Town & Country Planning Act 1990 (as amended)
Town & Country Planning (Development Management Procedure) (England) Order 2015

Porch to front and Loft conversion works including provision of two dormer windows to the front elevation and one dormer to the rear elevation. Re-roofing remainder of property and replacement of soffits, fascias and guttering. This application may affect the setting of a Listed Building.

9 Greenways Crescent Ferring

Thank you for your internet comments made on 8th October 2019 which has been recorded as **'an objection'** with the comments as follows:

9 Greenways Crescent
Ferring, BN12 5EF
Proposed Elevations
Scale 1:100 @ A3

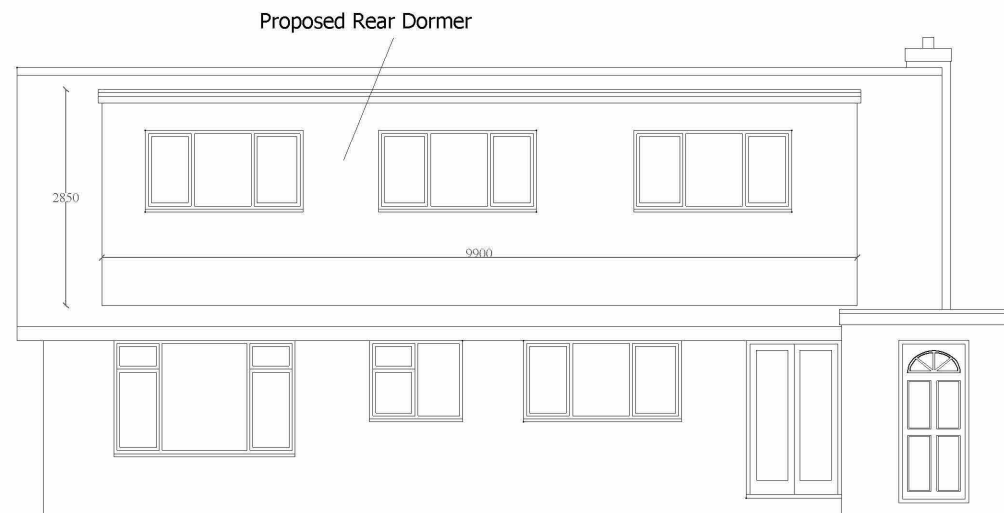
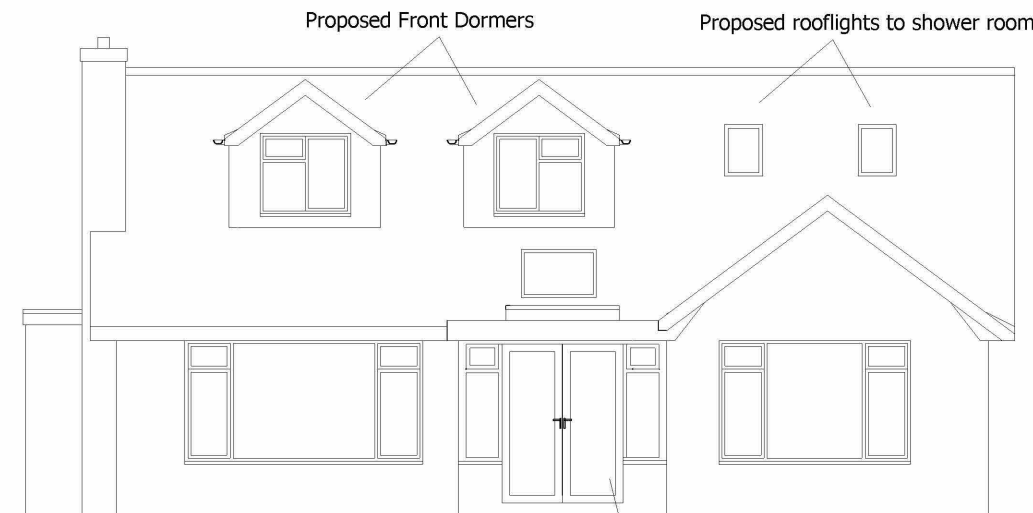
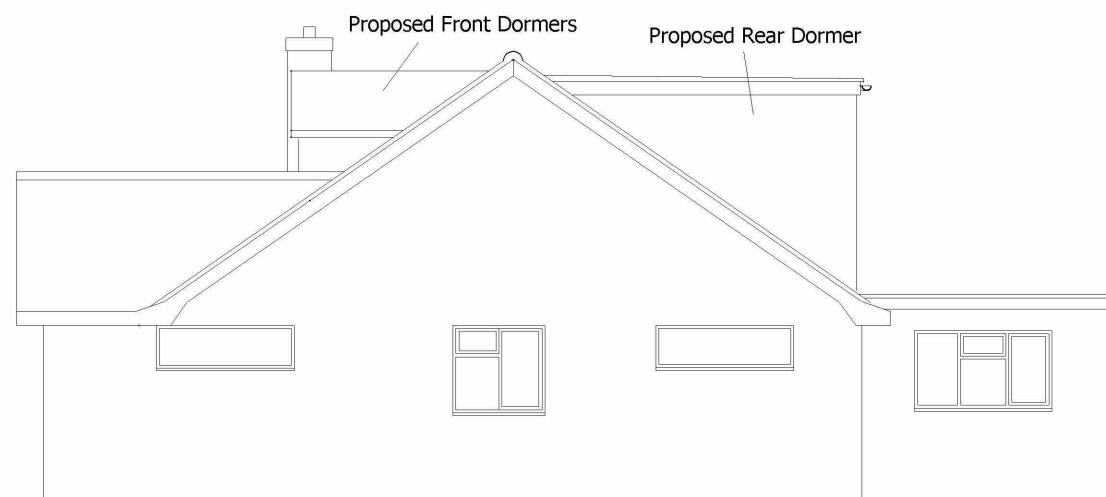
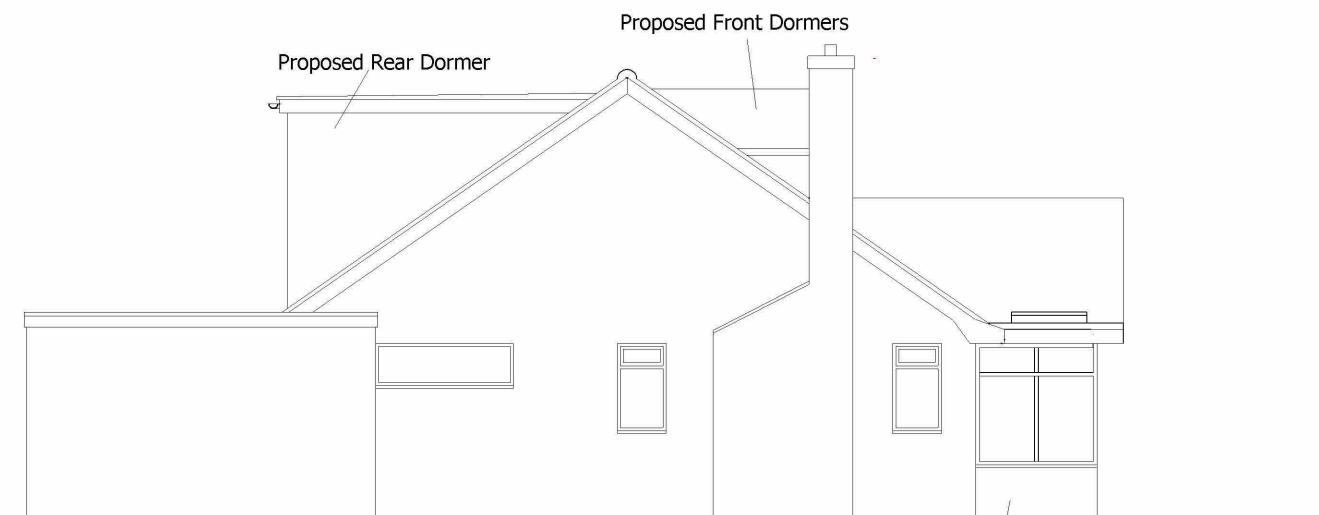
Having consideration for the size of the plot and the impact on neighbours, the large rear dormer is considered to constitute over-development. The rear dormer, by nature of its size and scale, would be overly dominant and disproportionate to the plot size contrary to Policy D DM1.
